7 January 2011

Our ref: CSE-12065D2977070

**Welwyn Hatfield District Council: Broadwater Road West (Allies & Morrison),
Welwyn Garden City
Planning application reference: N6/2010/2055/MA & N6/2010/2060/LB**

Illustrative ground floor plan of plot B and H

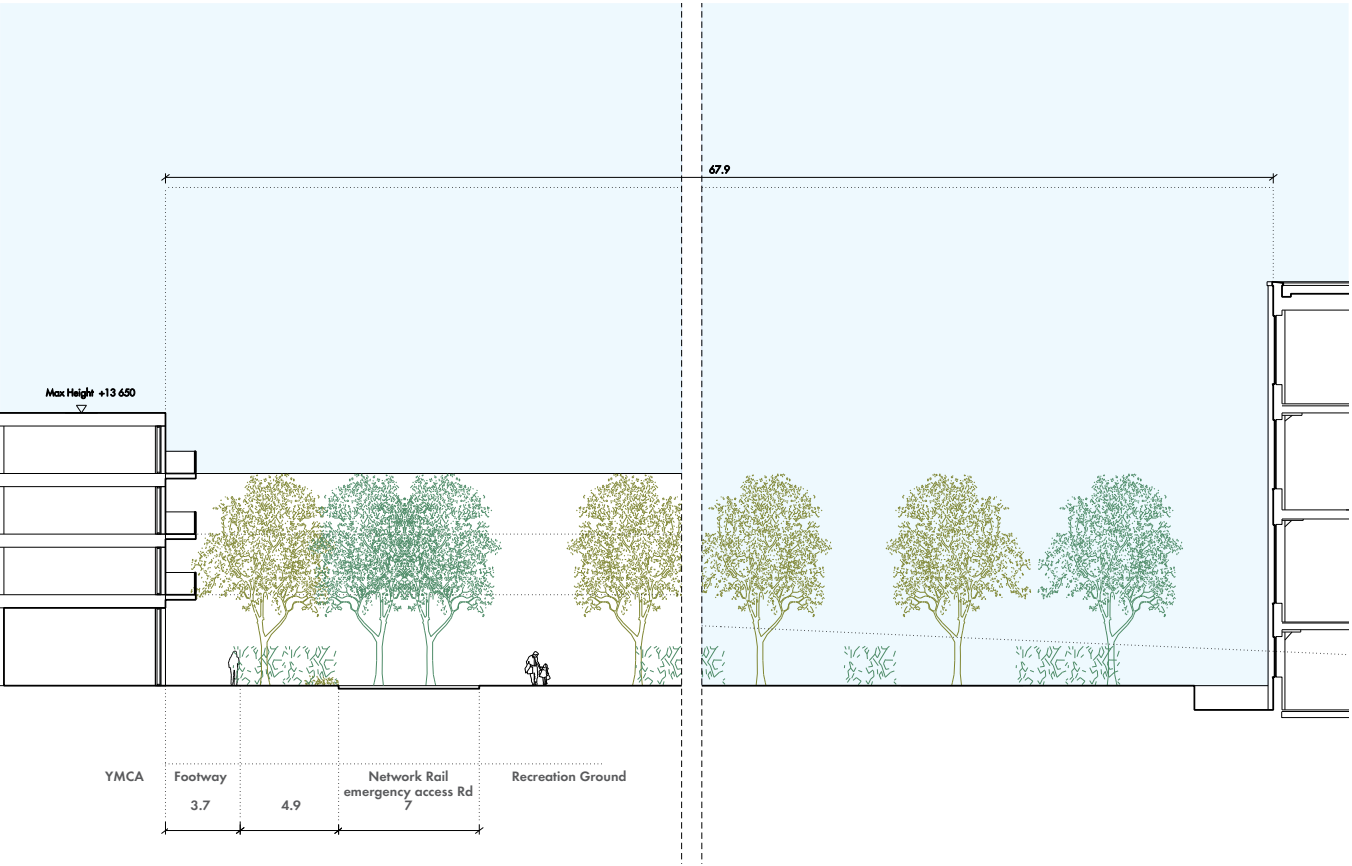
While we support the introduction of a large recreation ground within the north-west corner of the site, we think that separating it from the leisure centre by a car park is unsuccessful. We recommend that the recreation ground and leisure centre are better connected, perhaps helped by a redistribution of the car parking. We also think that the location of the station drop off and the route of the vehicular access to it should be reconsidered. The vehicle access and egress to the drop of point is rather convoluted, having to circle the residential area, turn around through the leisure centre car park and back track through the residential area again. This part of the site

is likely to become very congested at peak travel times and it is possible that commuters will use the access road to the supermarket car park as a drop off point instead.

4.3 Civic Square

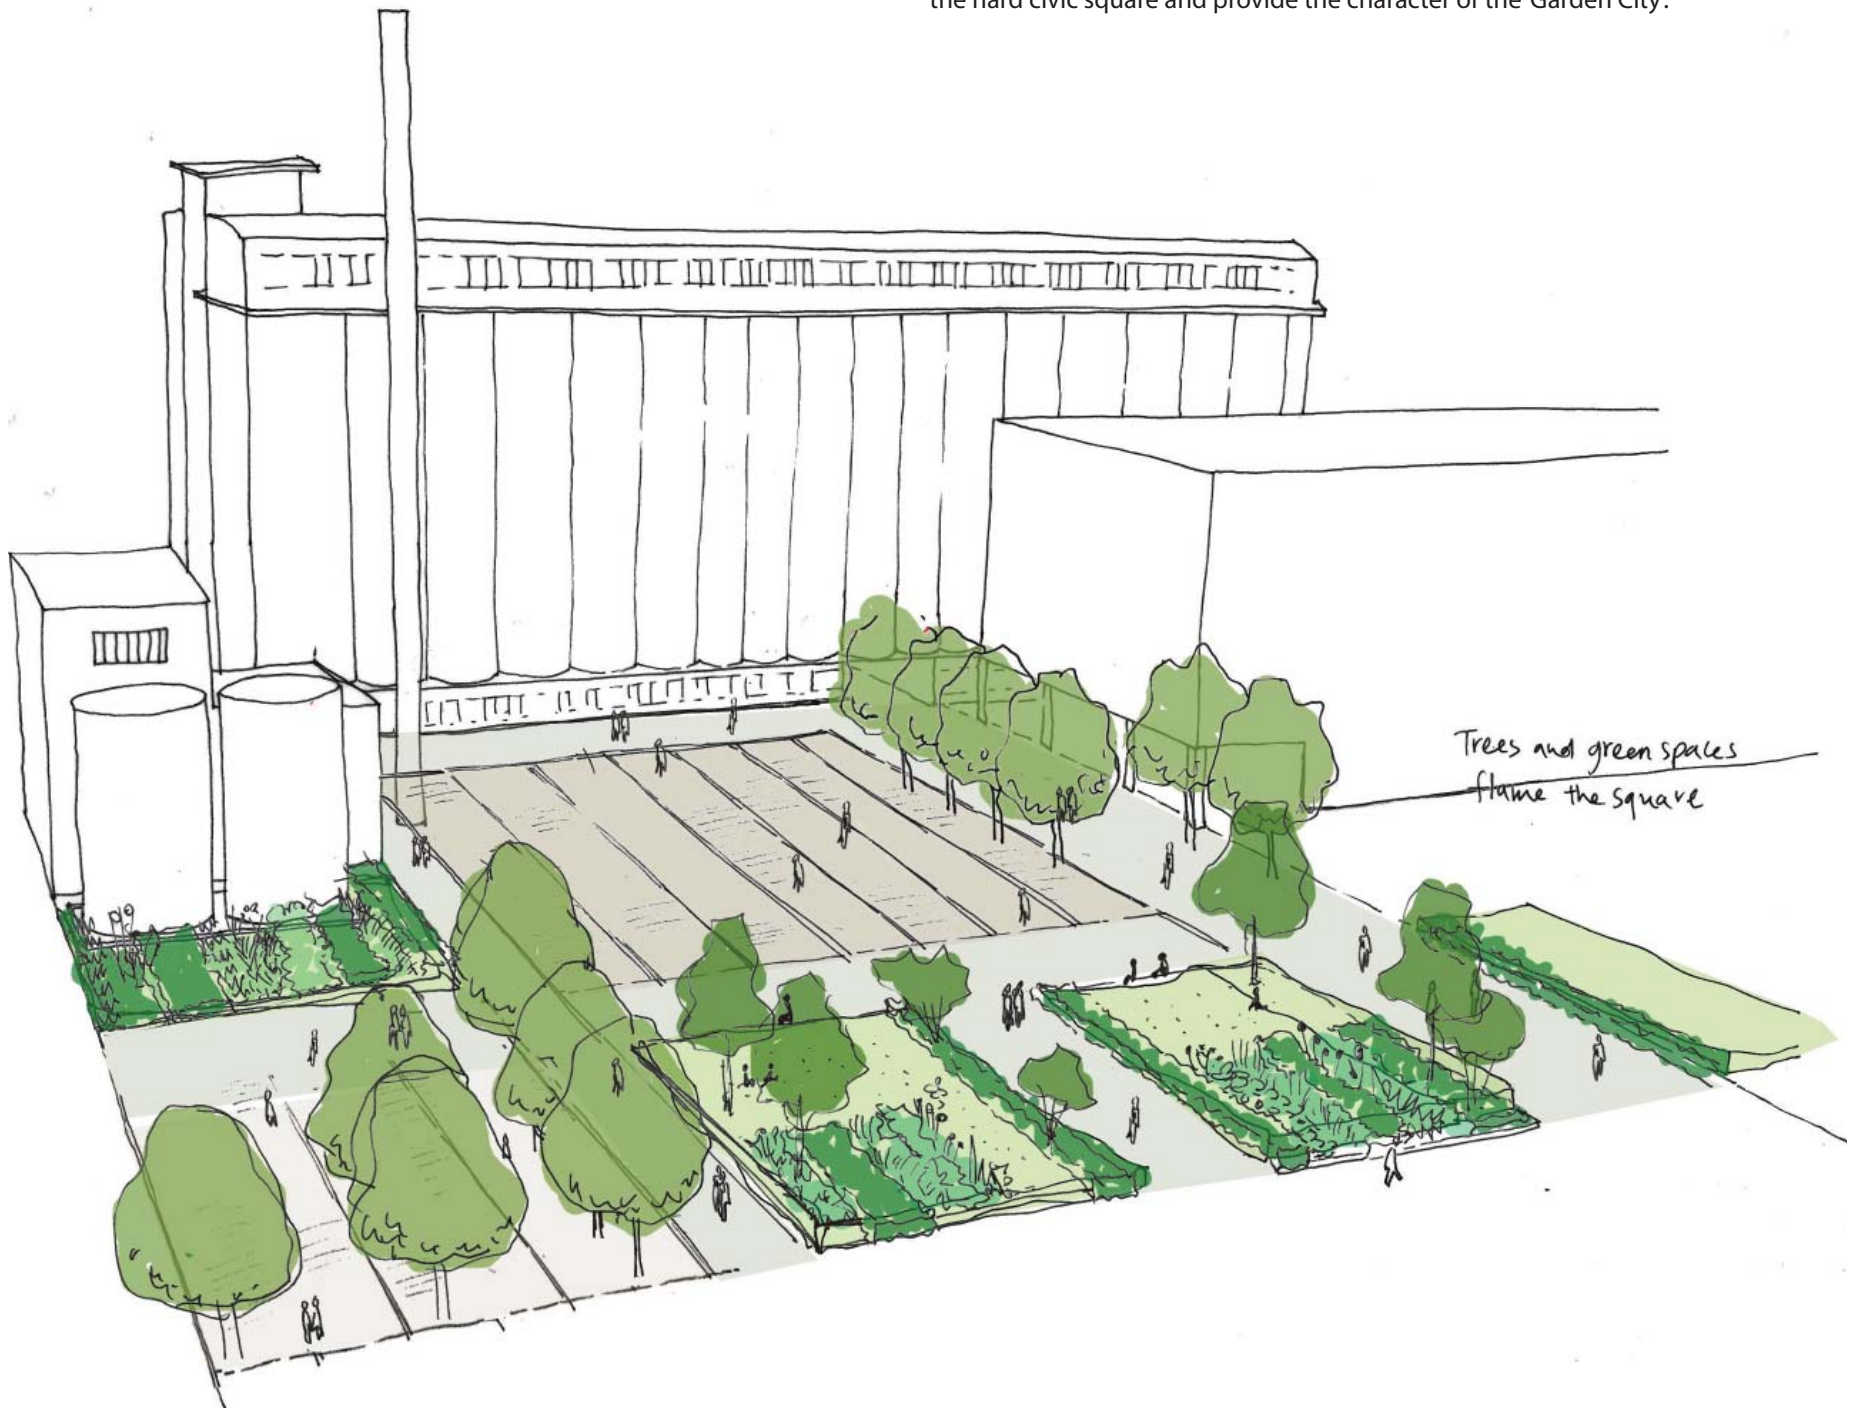
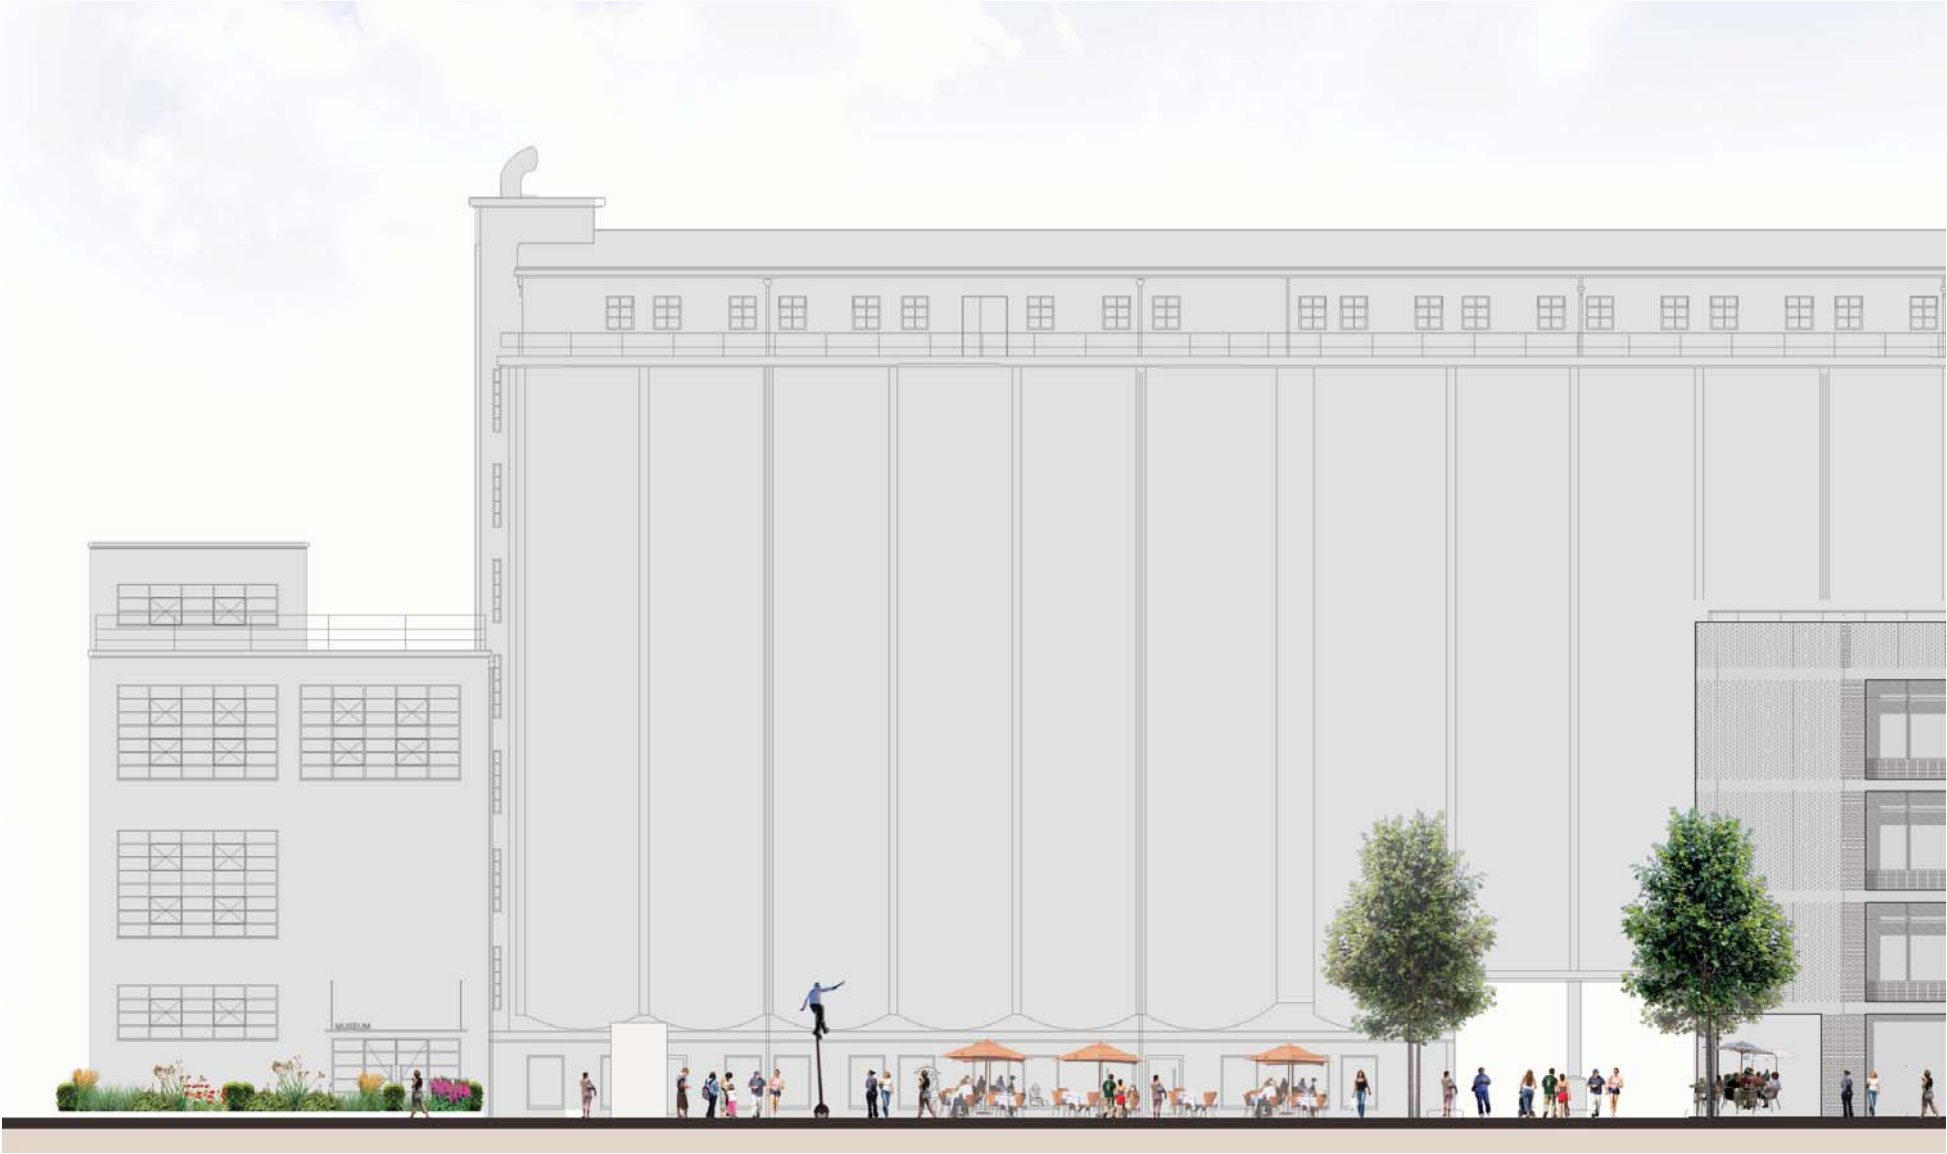
While it appears obvious for the civic square to be in the centre of the site, we remain unconvinced that it will have the feel of a piazza as envisaged. The space is poorly defined by the adjoining buildings, has multiple routes leading off it, some particularly wide, and is not demarcated as a purposeful place for public activities. We are concerned that the square will be difficult to animate and will lack bustle and life. We think greater clues should be taken from the squares within Welwyn Garden City that have a much greater presence. Moving vehicles could help to enliven this space and street furniture could play a role in suggesting ways that the civic square could be used.
